Address: 5, Croft Drive, Holmfirth, HD9 6HQ

| Application number: 2025/62/93161/W | |
| What is the application for?: | Removal of the existing garage and erection of detached dwelling including assoc |
| Address of the site or building: | adj, 3, Croft Drive, Honley, Holmfirth, HD9 6HQ |

West Elevation

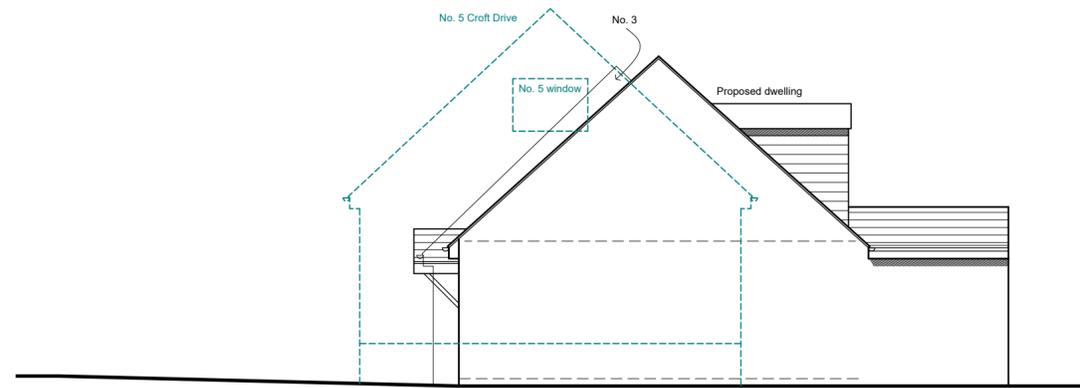
| On further viewing of the plans for the proposed new property adjacent to 3 Croft Drive I notice that a window on the gable end of the proposed property (on the first floor), on the west elevation, will be directly opposite my existing window. As this is a bedroom that is used I do not feel that it is appropriate to site a window in the proposed new property opposite an existing window. This will certainly be an invasion of my privacy and I would like the matter looking into before any planning permission is granted. | |
